**WELWYN HATFIELD BOROUGH COUNCIL
EXECUTIVE DIRECTOR - PLANNING, PUBLIC PROTECTION AND GOVERNANCE**

Application No: 6/2019/0276/HOUSE
Location: Just House Coopers Lane Northaw Potters Bar EN6 4NJ
Proposal: Erection of front garden dwarf wall with steel railings and electric gates and installation of two new accesses following removal of existing
Officer: Ms Lucy Hale

Recommendation: Refused

HEIGHT AND PROFILE OF GATE IN ORIGINAL PLANNING APPLICATION WHICH WAS REFUSED

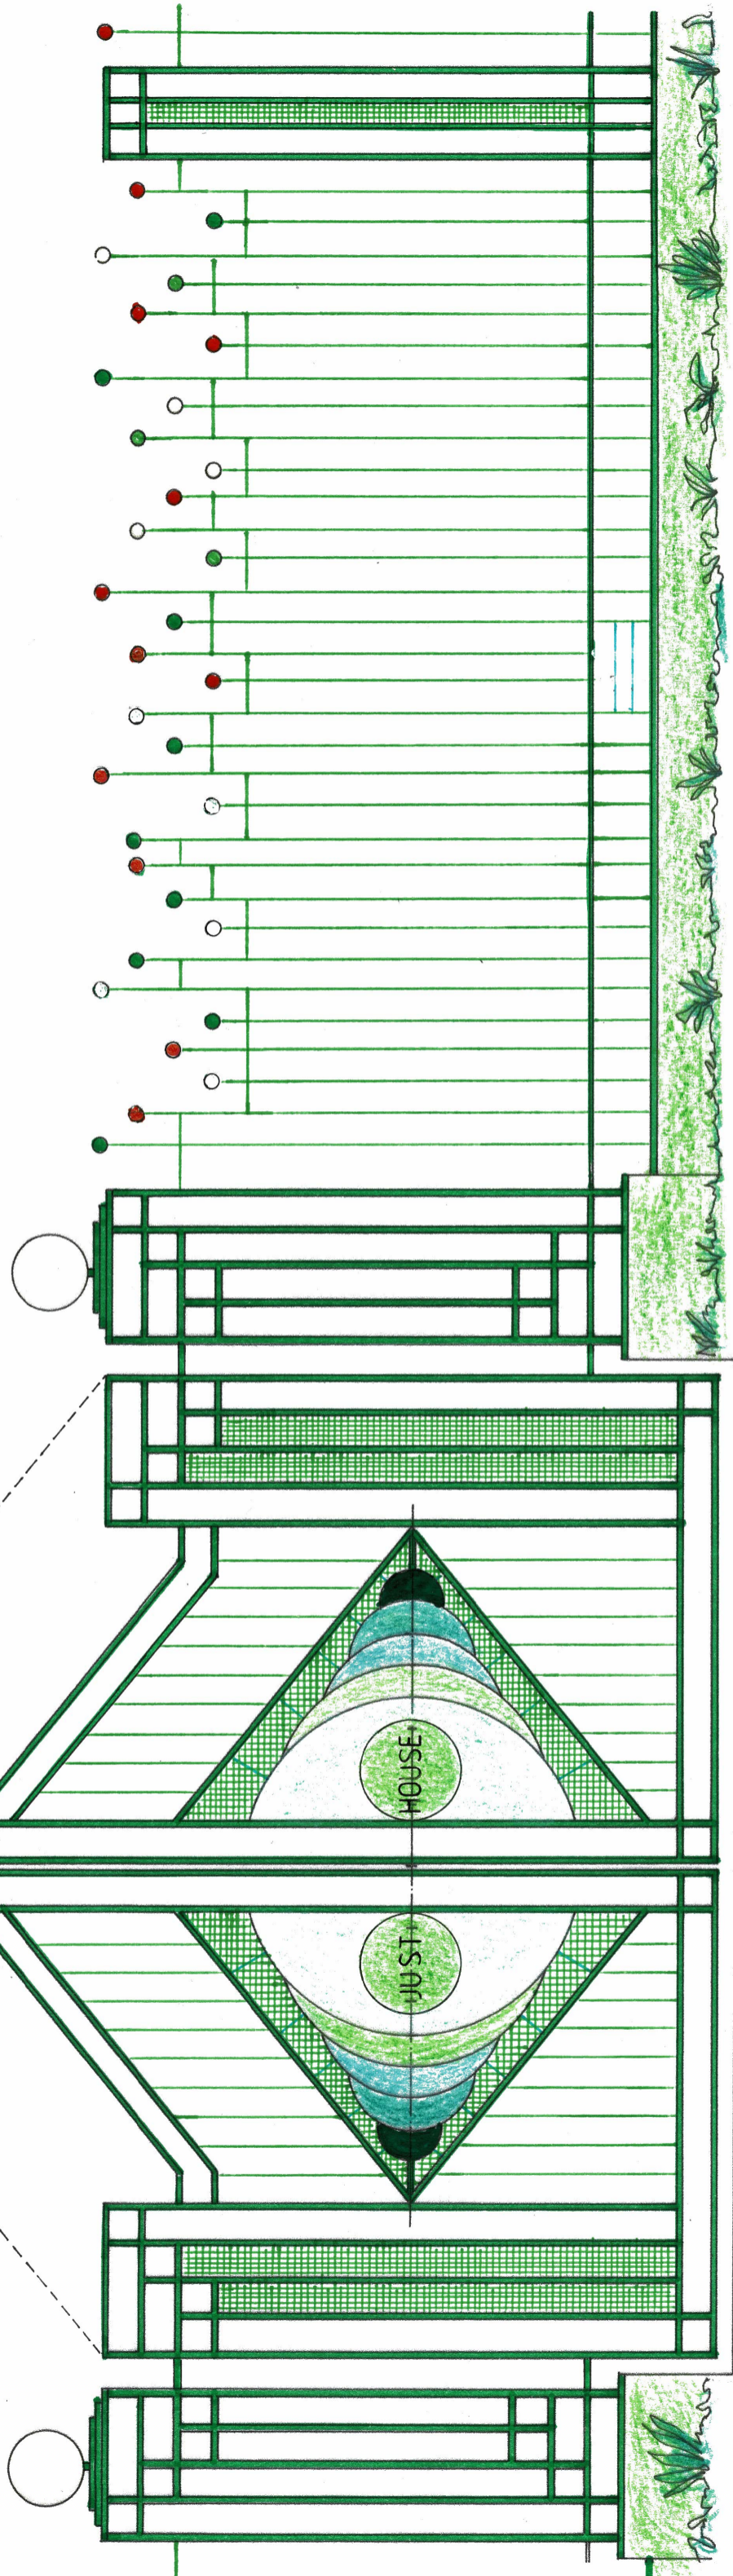
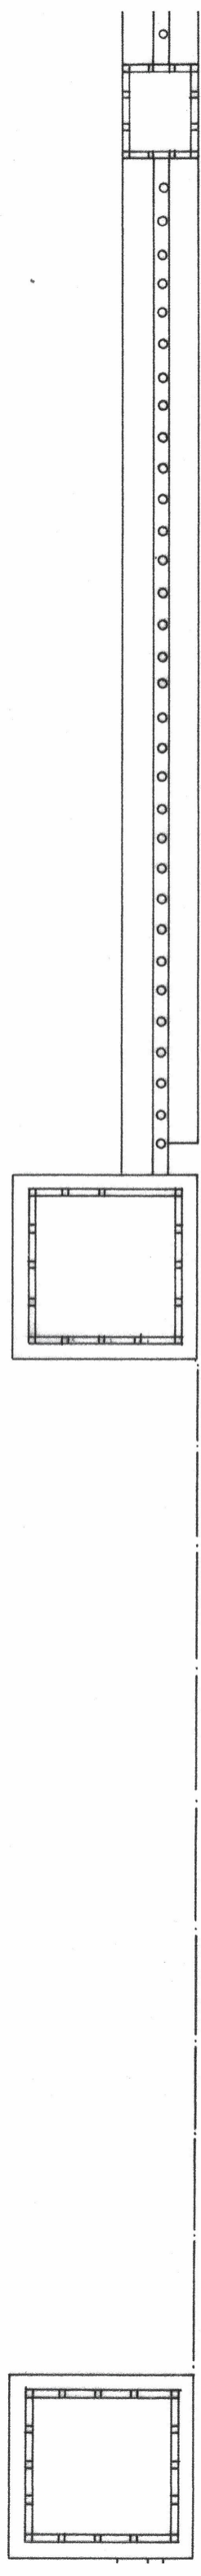
The existing site benefits from an approximately 1.1 metre high timber and wire link fencing. The application seeks planning permission to replace the existing boundary treatment with a 2 metre high boundary treatment comprising a 1.8 metre high iron railings above a rendered dwarf wall, together with 2.3 metre high pillars at their highest point. There are two gates proposed which would measure approximately 2.5 metres high at the tip by approximately 3.4 metres wide.

The proposed gates have been reduced by approximately 1 metre. Minor design alterations have been made to the gates however these are not considered to have significantly changed the scale for the proposal. The scale of development proposed would be extensive and materially larger than the existing fence. As a result the proposal is inappropriate development in the Green Belt contrary to both local and national planning policy.
